2280.08-DRAWING REVISION SCHEDULE

MOD18 - A1103 - PROPOSED PLAN-L04-CIRCLE LOBBY-LOWER CIRCLE**VIEW 1 – MEZZANINE LEVEL**

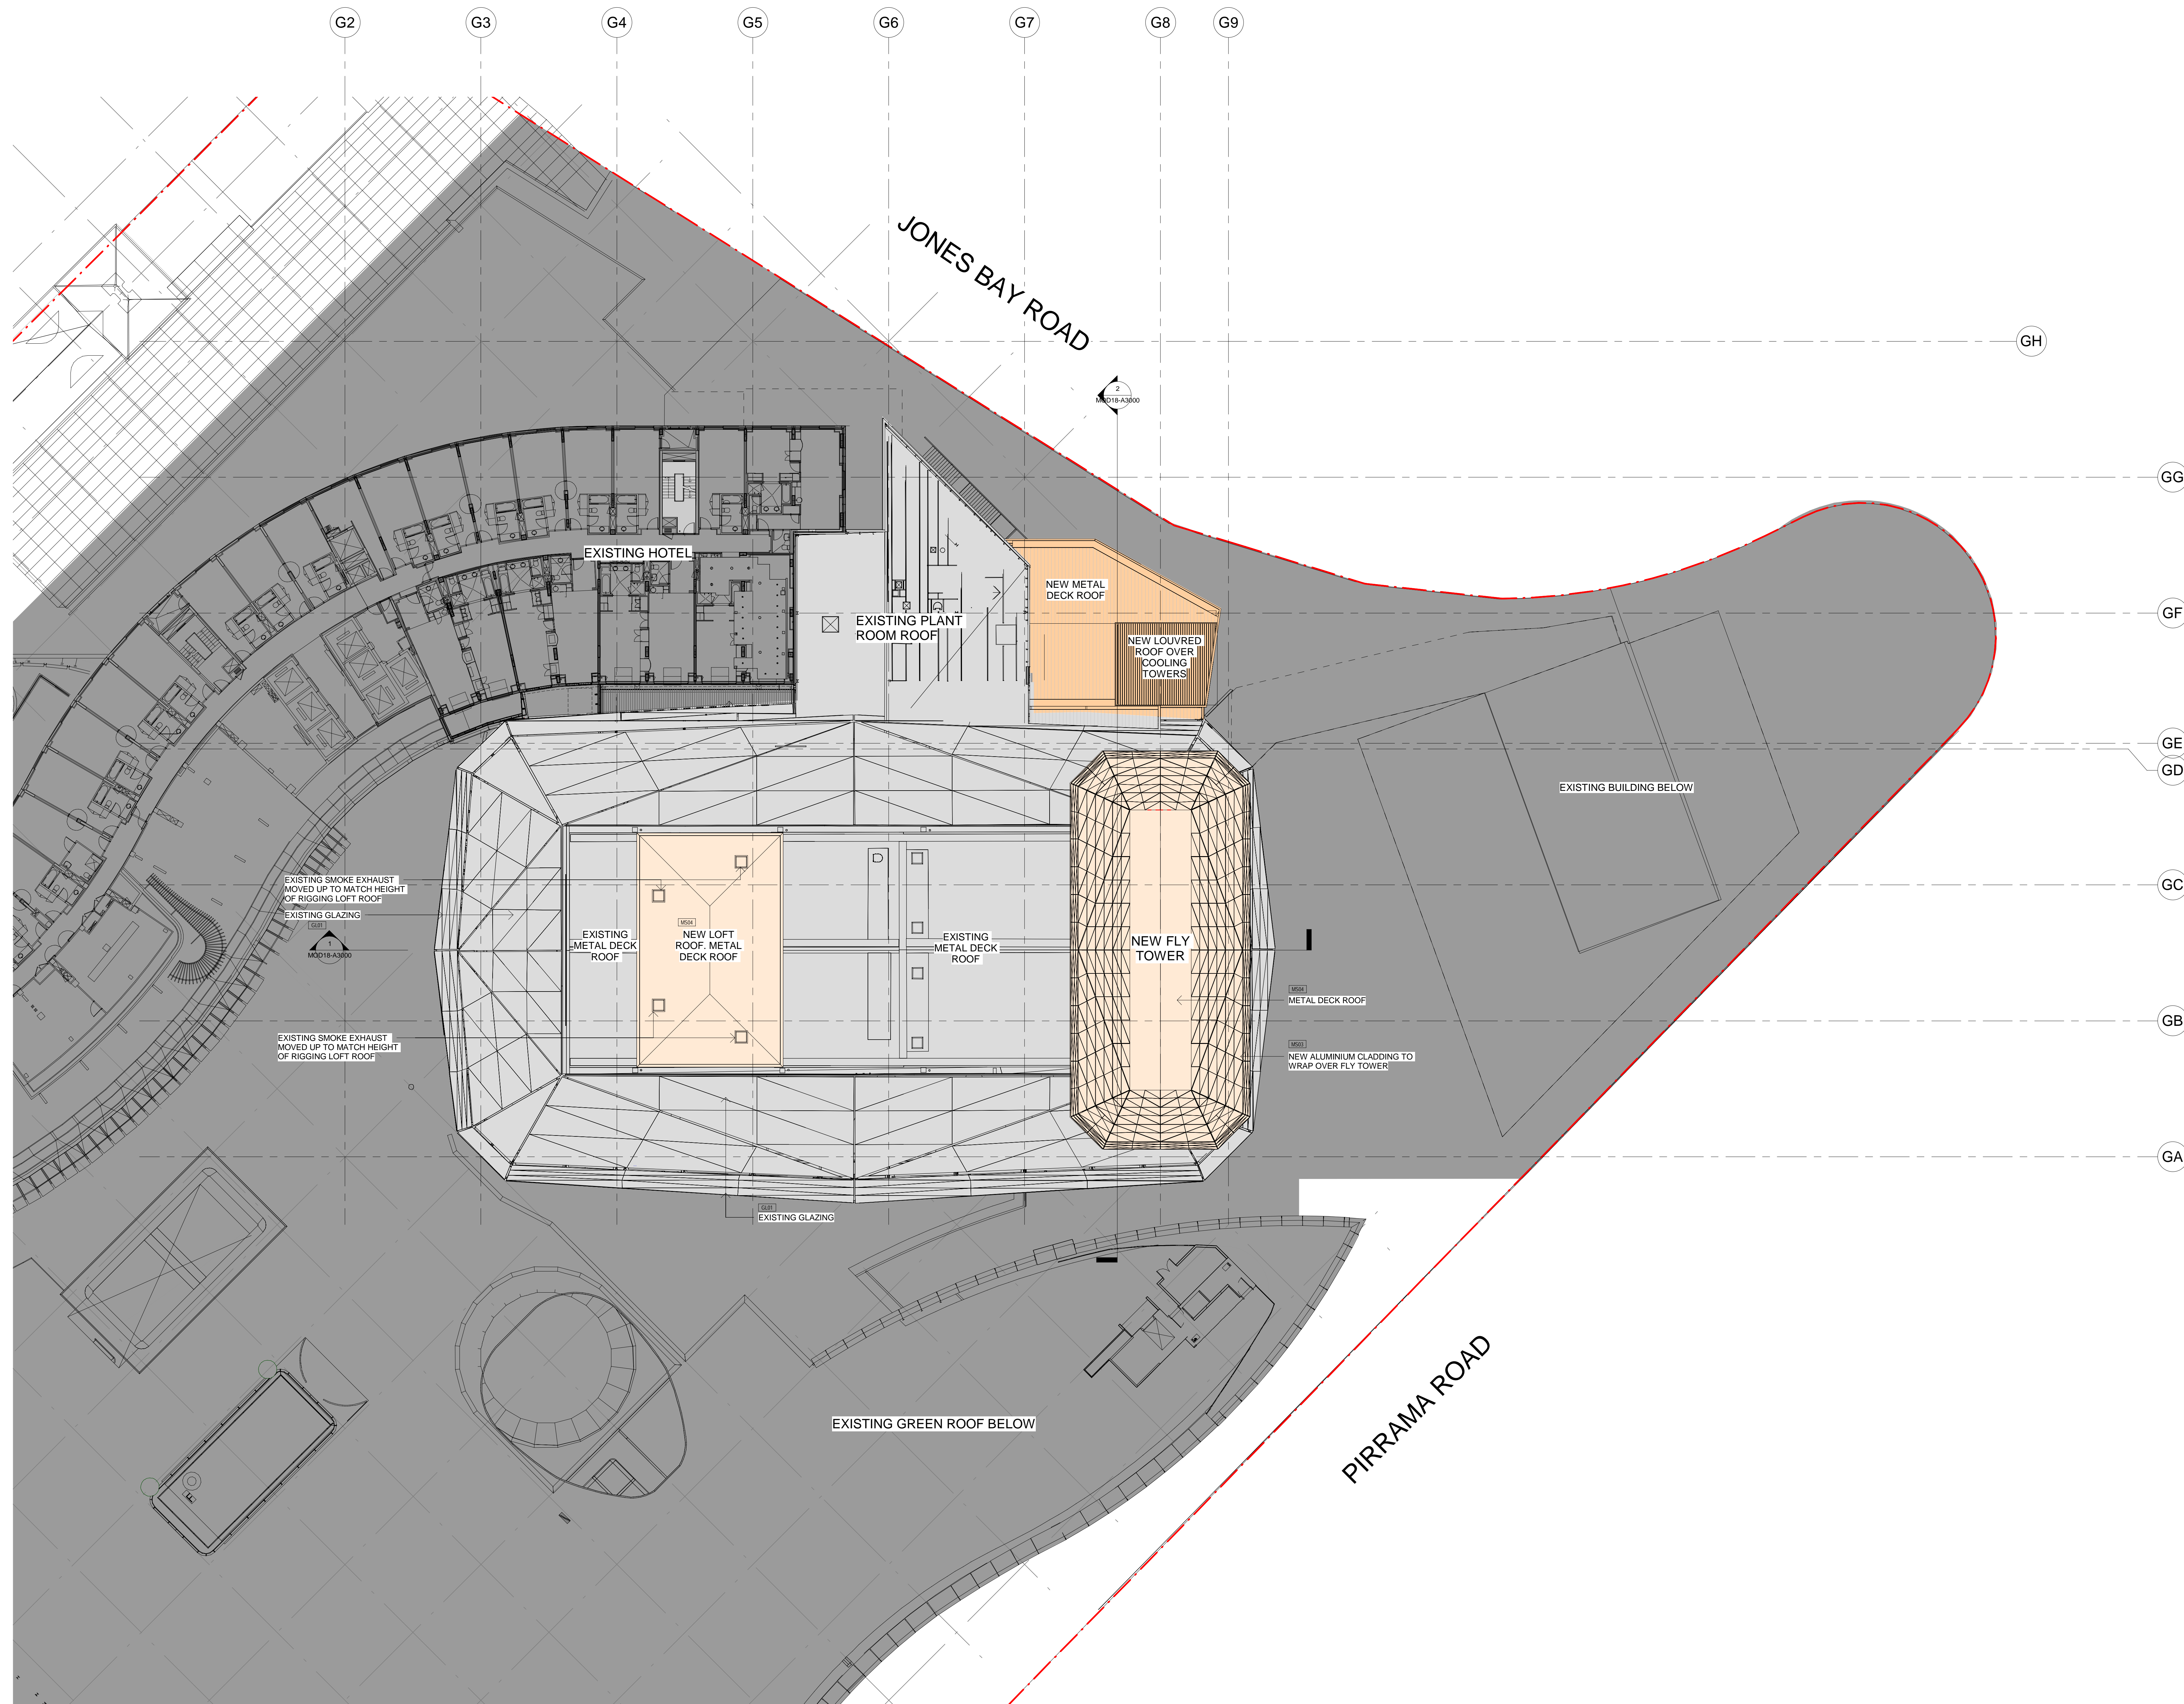
1. Callout added to clarify route from existing loading dock to stage.
2. Area calculations revised to suit revised scheme.
3. 1.5m high egress from level 03 of dressing rooms added. This is in approximately the same location as the existing egress stairs from the existing dressing room. Note, stairs is on level 03 below and does not extend up to level 4. Refer to elevations

1 SECTION
1 : 100

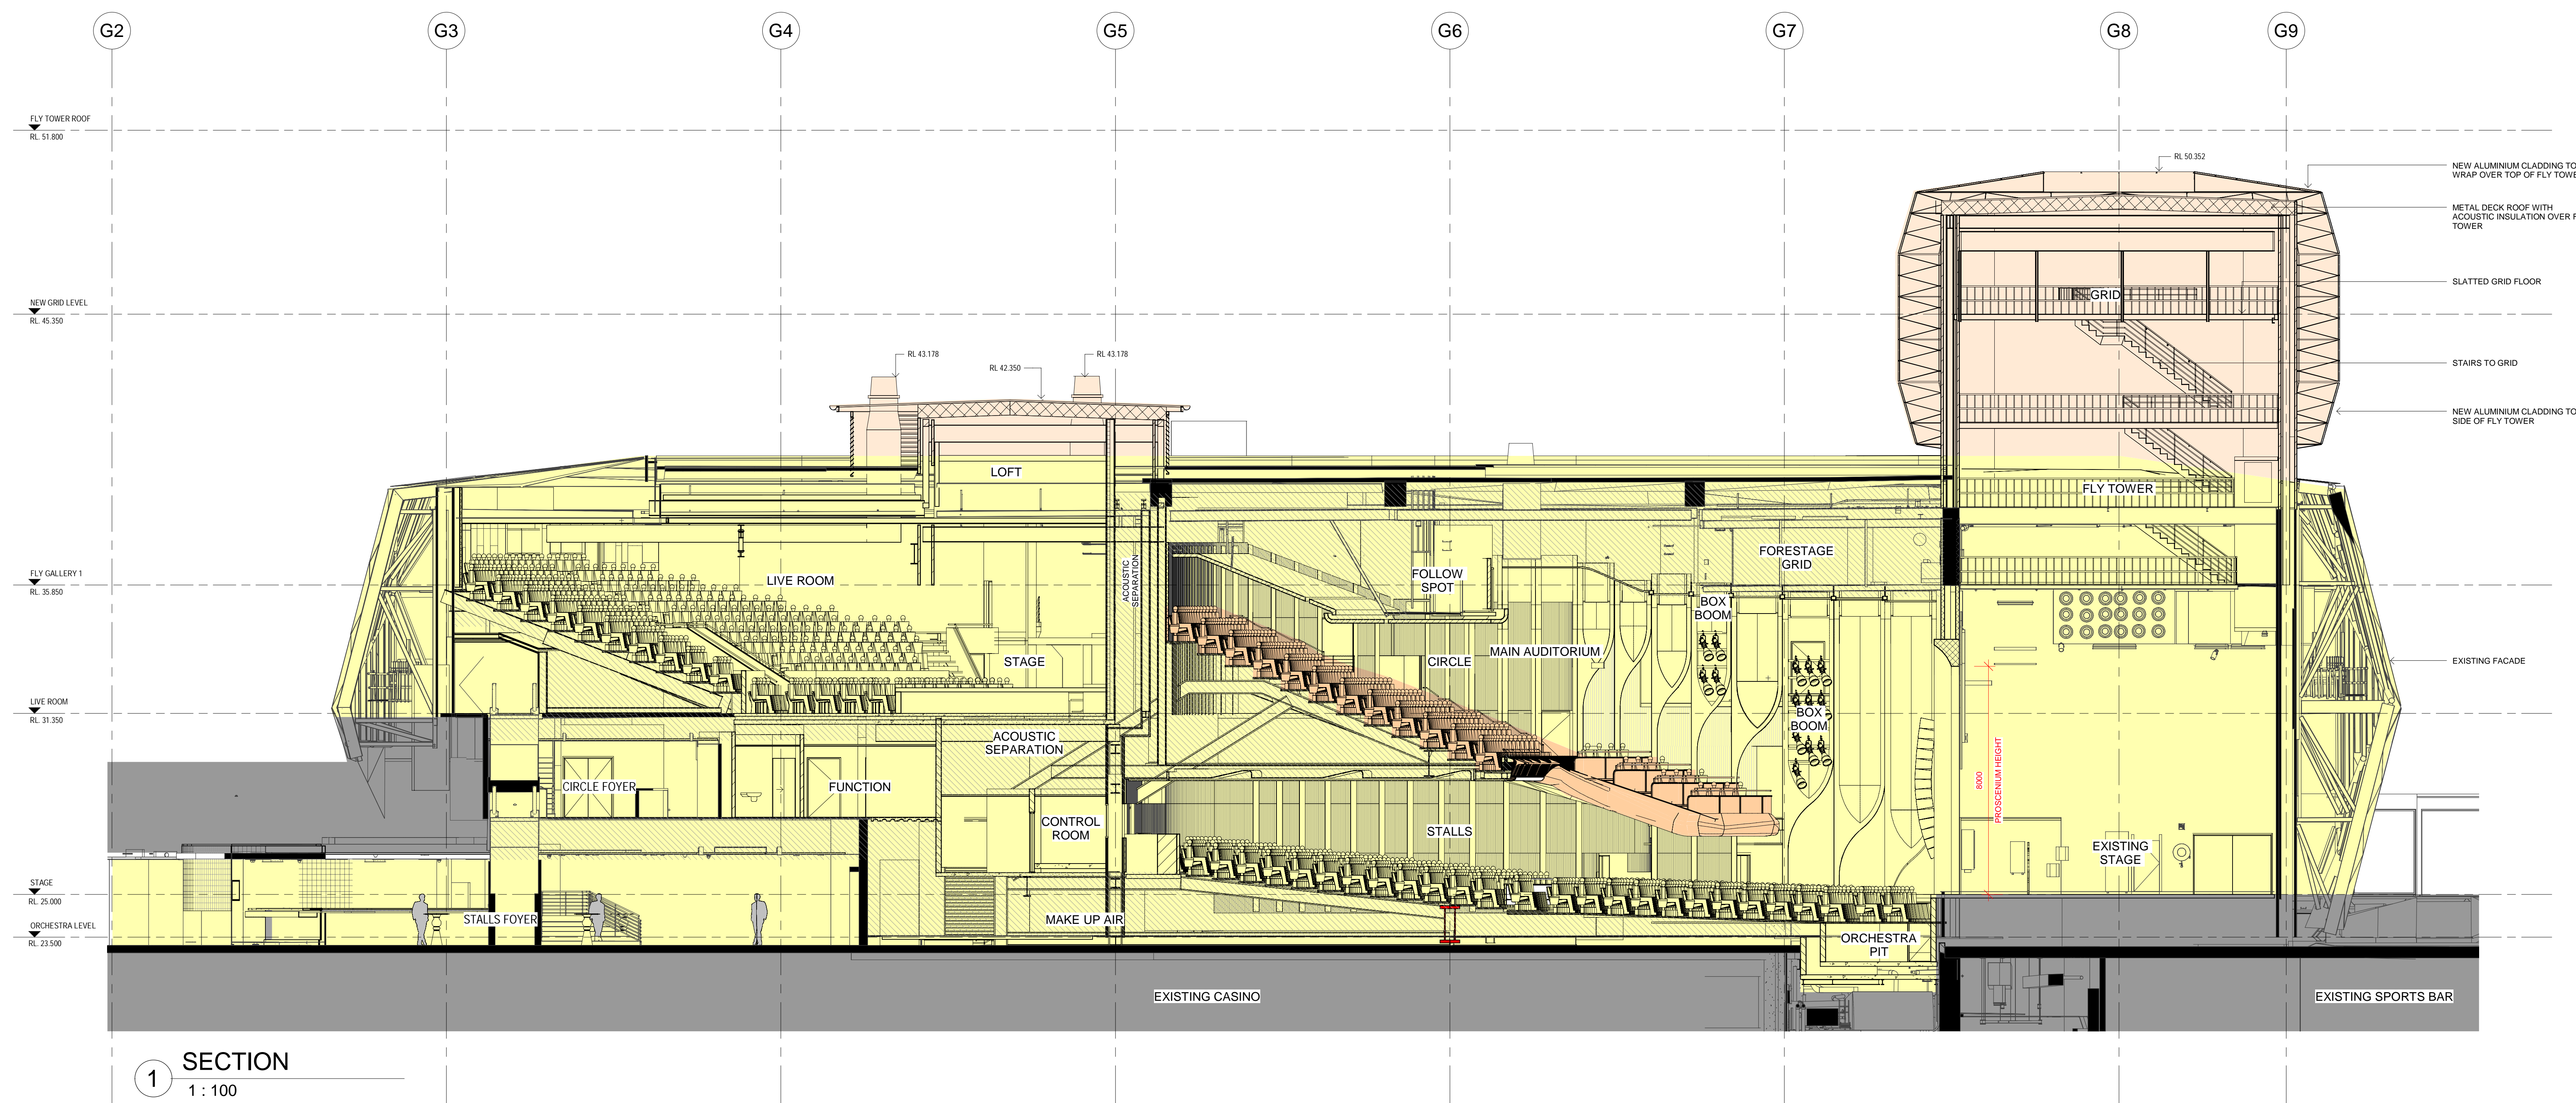
1. Footprint of fly tower reduced to suit comments from DPE and City of Sydney.
2. Dimensions of proscenium added for clarity

2 SECTION
1 : 100

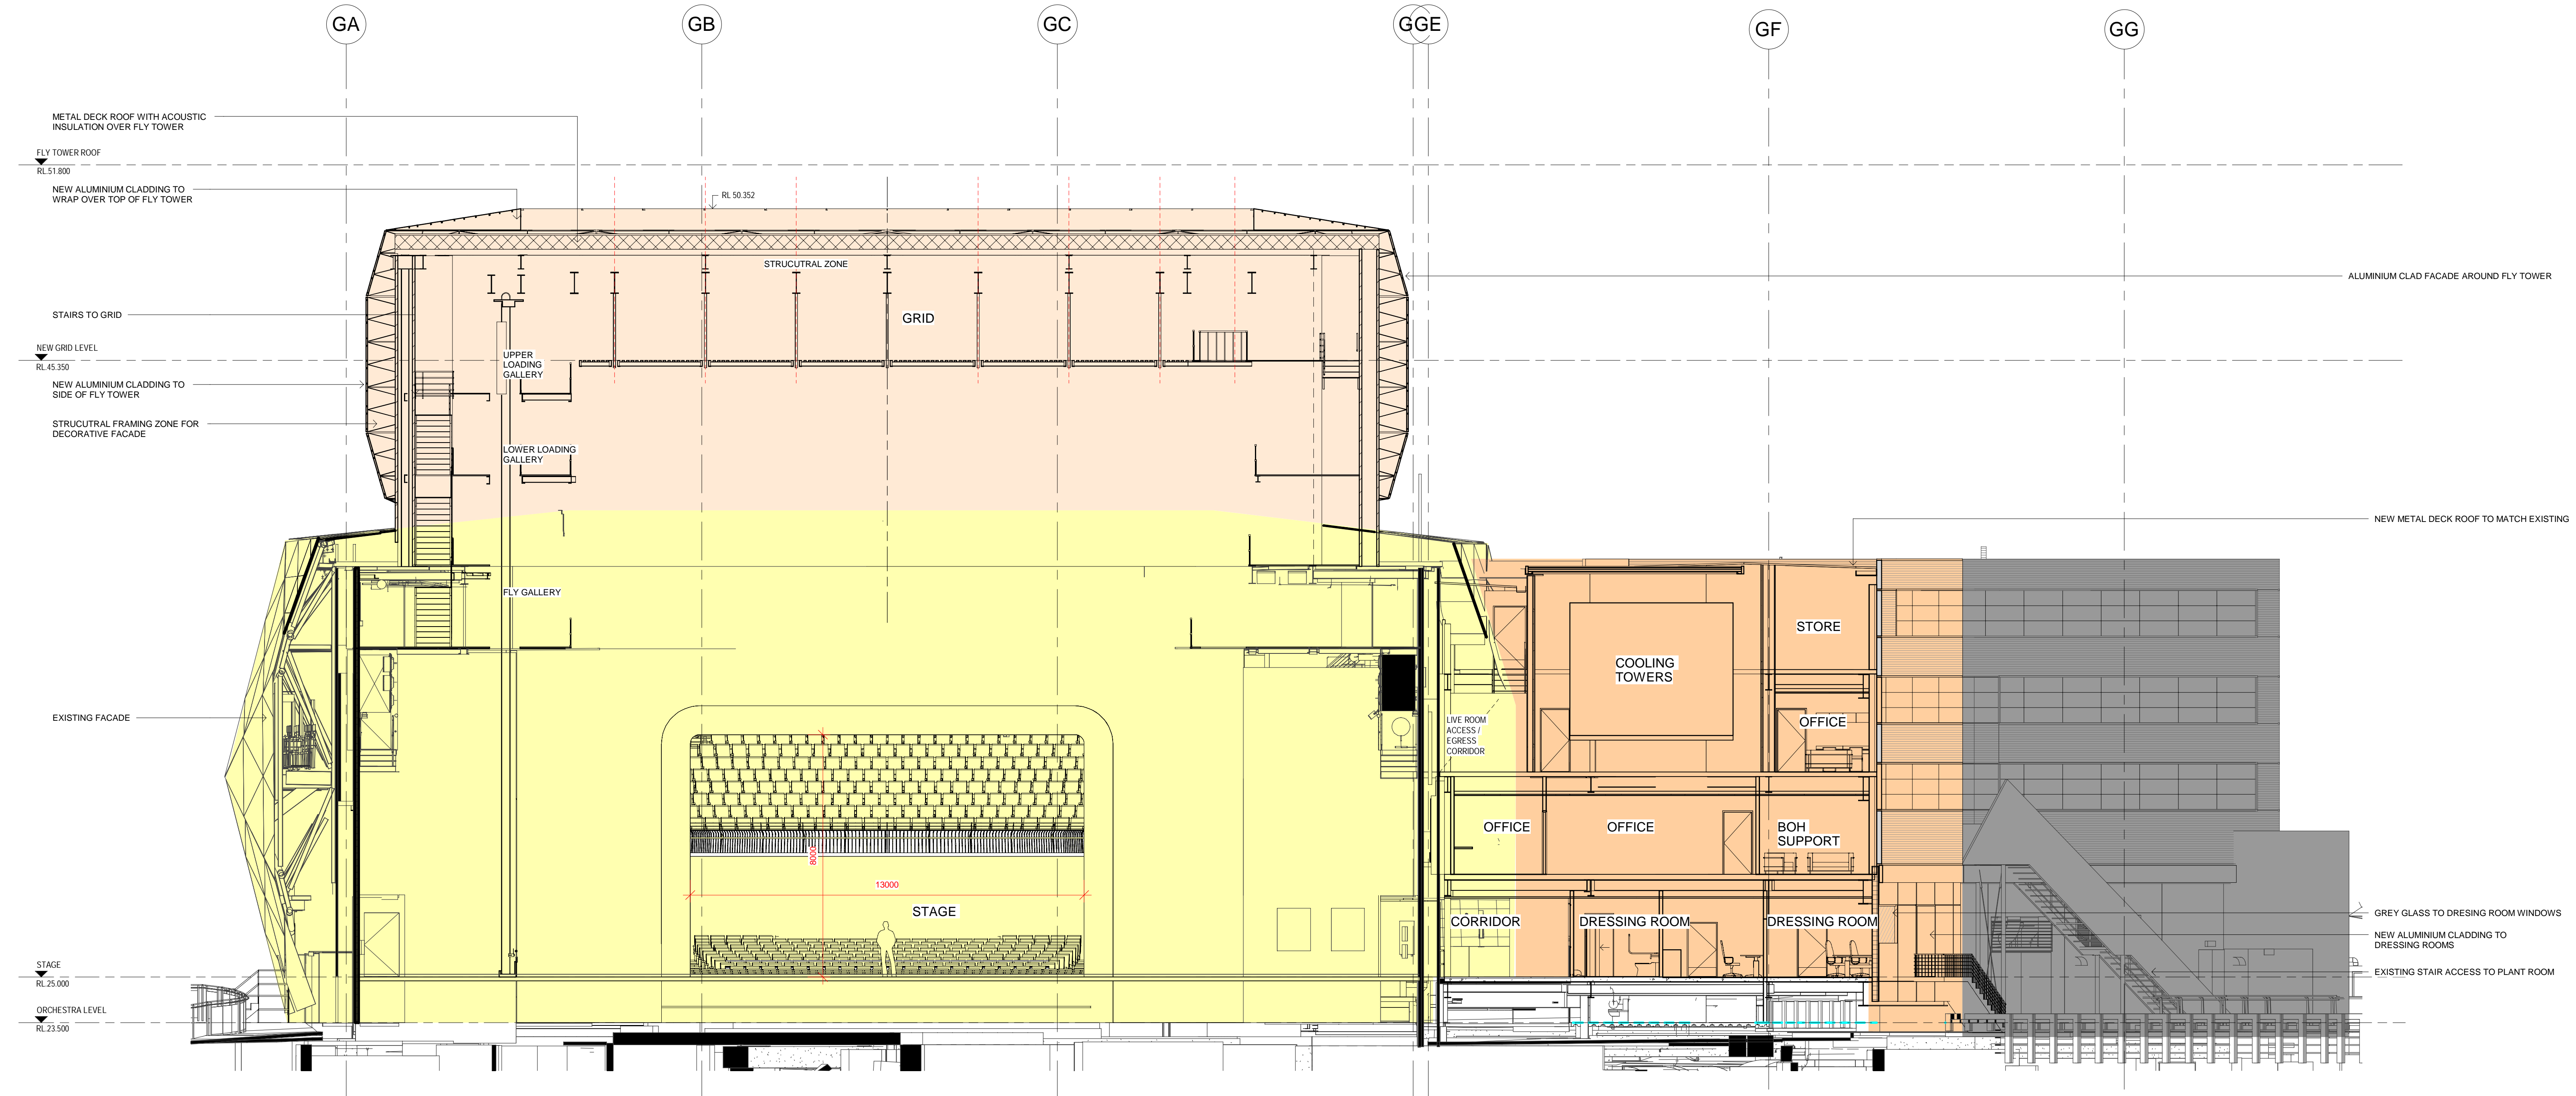
1. Footprint of fly tower reduced to suit comments from DPE and City of Sydney.
2. 4 level extension over existing dressing rooms reduced to 3 levels over existing dressing rooms. Aluminium clad screen extending from 4 level extension and on front of existing plant room omitted.
3. Double height plant room extension omitted from scope.
4. Dimensions of proscenium added for clarity
